BARGHAUSEN

RE: Responses to Comments
White Barn – Chick-Fil-A
Highway 9 and Soper Hill Road, Marysville, Washington
Permit No. PA23-019 / Our Job No. 22579

The following outline provides each of your comments in italics exactly as written, along with a narrative response describing how each comment was addressed:

# PRELIMINARY SITE PLAN FOR CHICK-FIL-A MARYSVILLE

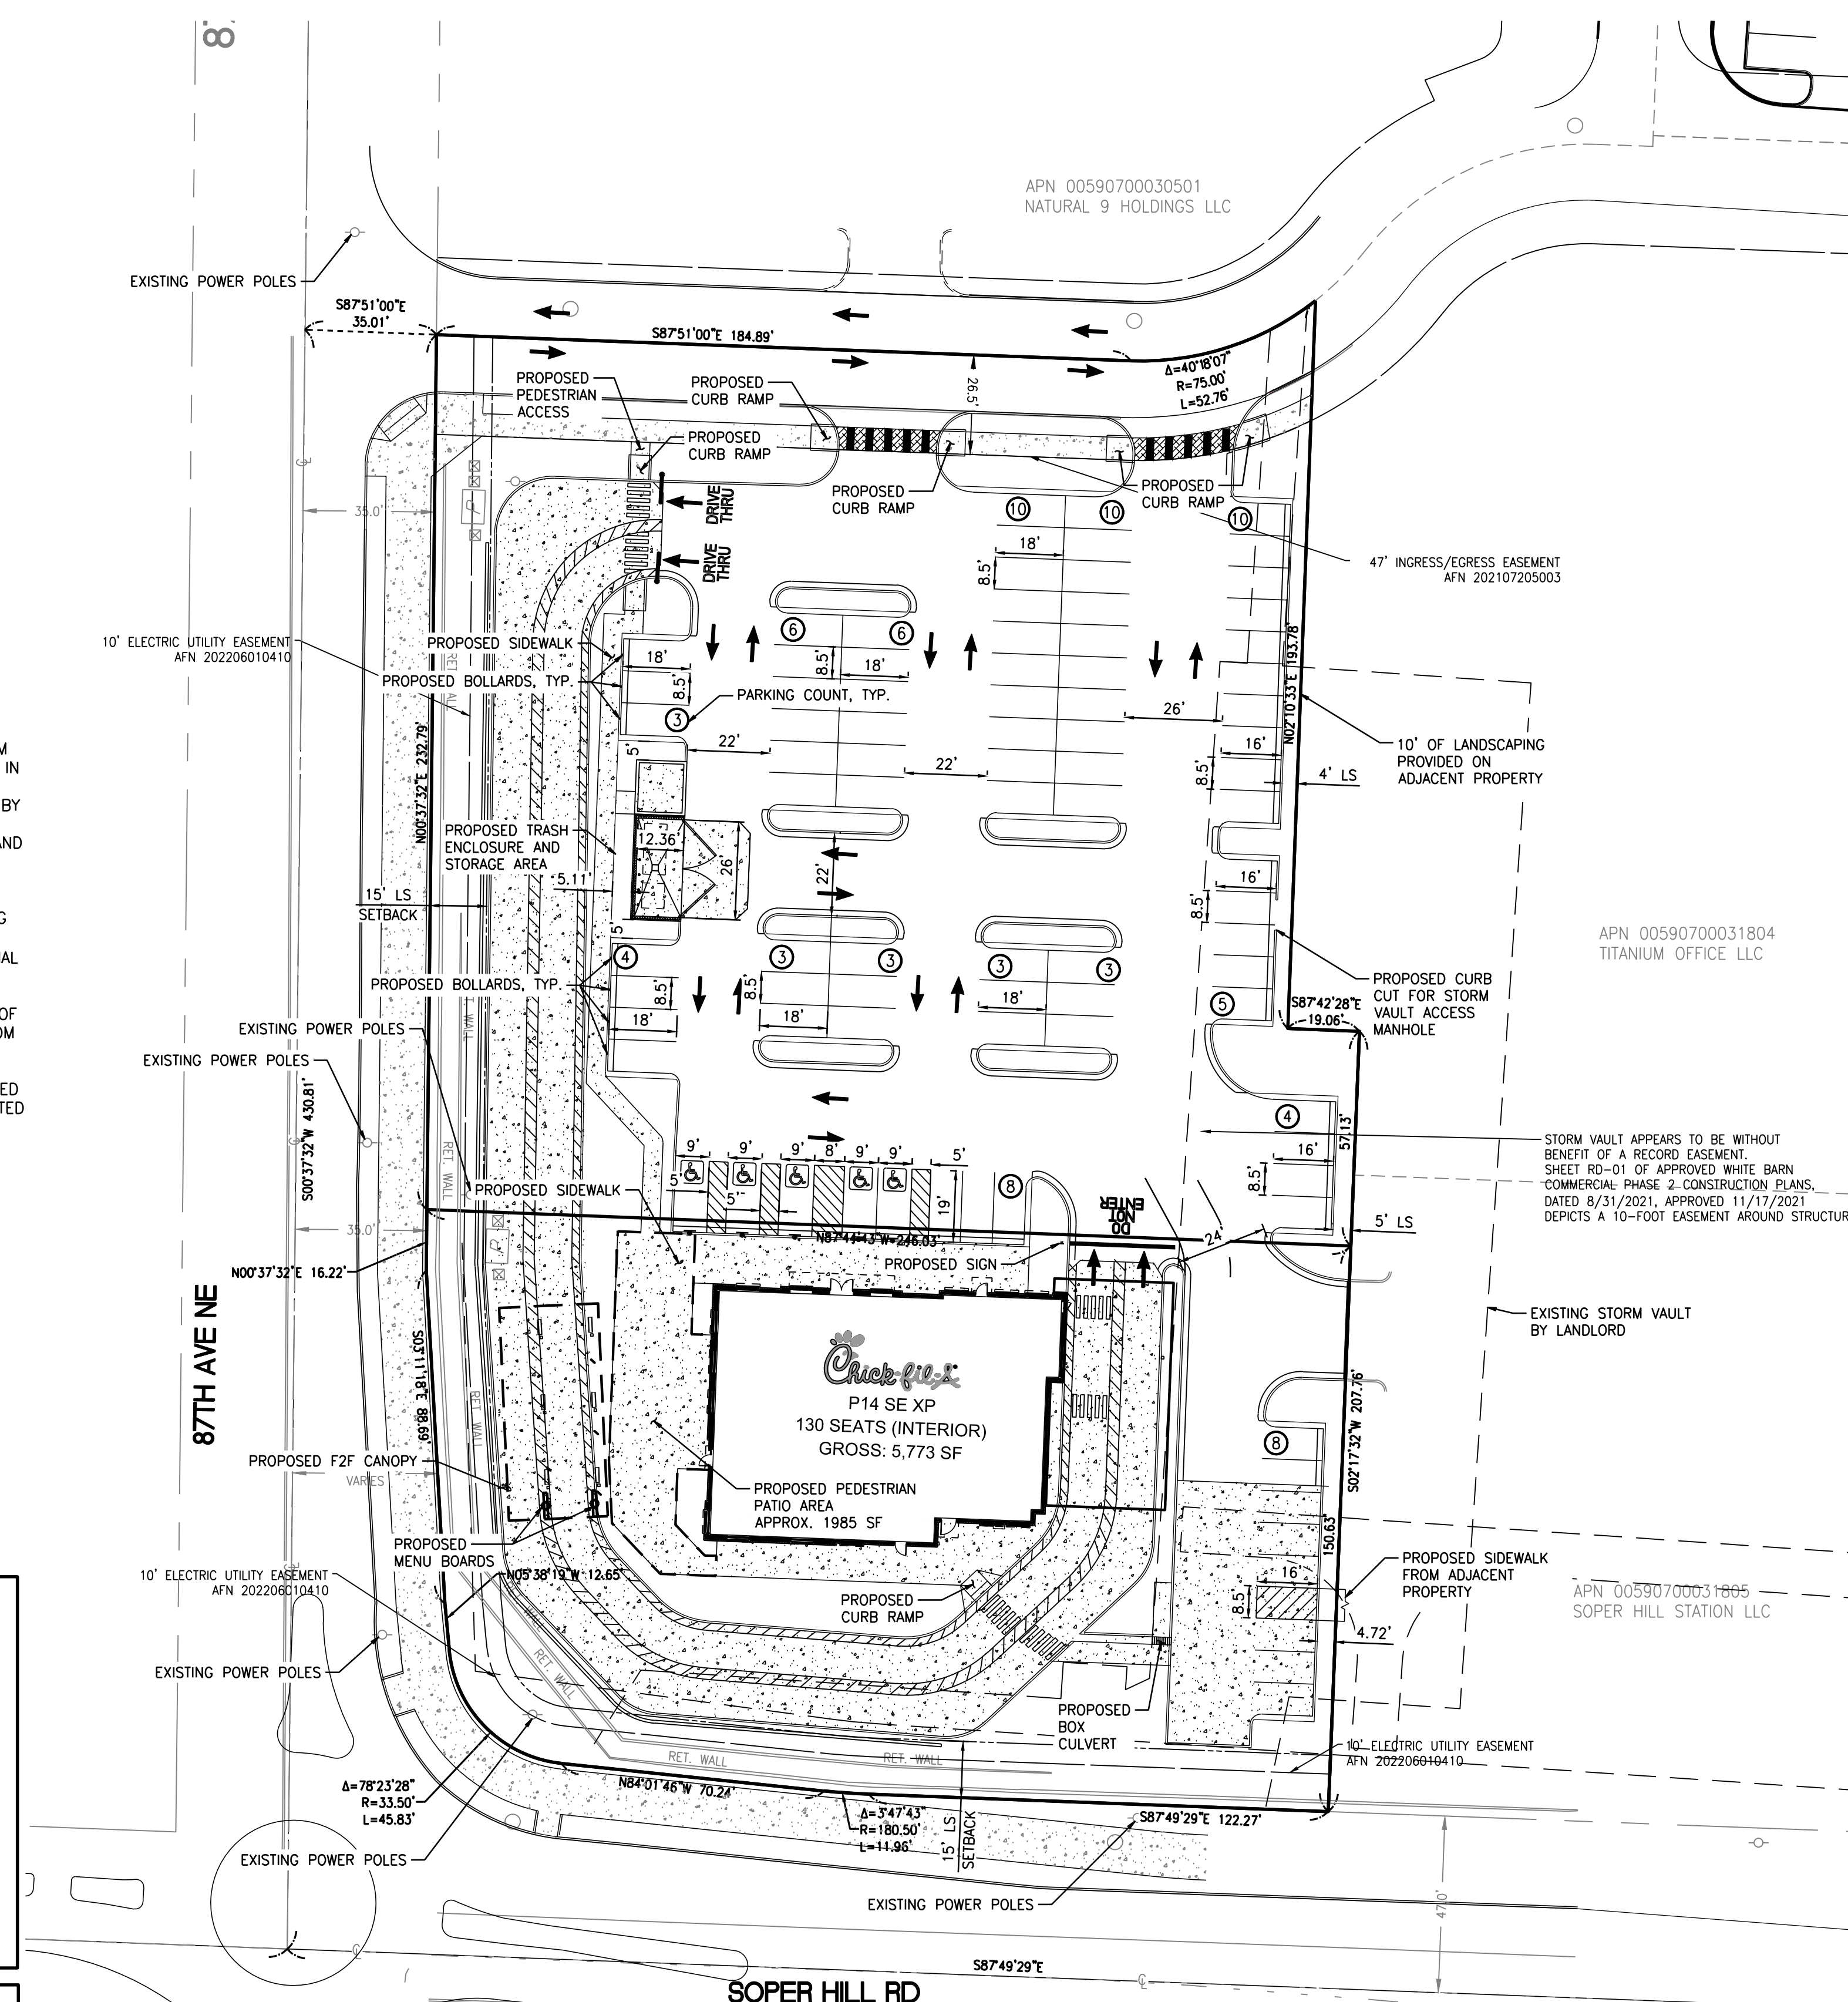
- a. *Provide the required 30' L3 buffer on Soper Hill Road and 87th Avenue NE.*

- c. *Provide the required 15' L2 landscape buffer between Soper Hill Road and 87th Avenue NE drive-thru lanes. This can be incorporated into the required within a portion of the required 30' L3 landscape buffer.*

- d. *Provide the required 5' wide L2 landscape buffer between the parking areas and drive-thru. It appears a pedestrian sidewalk is proposed instead of the required landscaping.*

- e. *Provide a minimum 5' wide L1 landscape buffer around the proposed dumpster enclosure.*

- g. *No more than 50 percent of the 87th Avenue NE frontage may be occupied by vehicular access or parking.*

- j. *The pedestrian crossings along the north entrance shall be constructed with decorative concrete, similar to what has been installed on the White Barn development site. This detail will need to be provided.*

- k. *Provide required open space calculations. Non-residential uses shall provide pedestrian-oriented space, defined in subsection (2)(c) (see design standards for qualifications), at a rate of 2% of the site, plus 1% of the building floor area. Required sidewalks and walkways shall not count as pedestrian-oriented space. See MMC 22C.070.100(2)(c) for examples of qualifying pedestrian oriented open space.*

- l. *Add the following notes:*

Response: Per a meeting with Chris Holland and Marysville Municipal Code Section 22C.070.210(2)(a)(iv), the buffer may be reduced should this meet the intent of the standards and guidelines. Two examples of other screenwalls have been provided for reference. These would both accomplish the intent of code by providing something visually appealing and blocks the headlights. More dense landscaping can also be provided in this buffer beyond what Type L3 requires.

Response: The 15-foot L2 landscape buffer is incorporated into site plan.

Response: The 5-foot-wide L2 landscape buffer between parking areas and drive-through is provided to the maximum extent feasible due to site constraints.

Response: The 5-foot-wide L1 landscape buffer is provided around the proposed trash enclosure.

Response: Due to site constraints, the drive-through location must be along the frontage of the site. Screening is provided by the 15-foot landscape buffer and screenwall.

Response: Decorative concrete will be provided at pedestrian crossings along the north entrance. Detail will be provided with permit plans and has been shown with a new hatch on the site plan included with this submittal.

Response: With a site area of 90,528 square feet and a gross floor area of 5,773 square feet, the project is required to provide approximately 1,867 square feet of a pedestrian oriented area. There is a pedestrian area on site provided that is approximately 1,985 square feet.

Response: Notes have been added to the site plan.
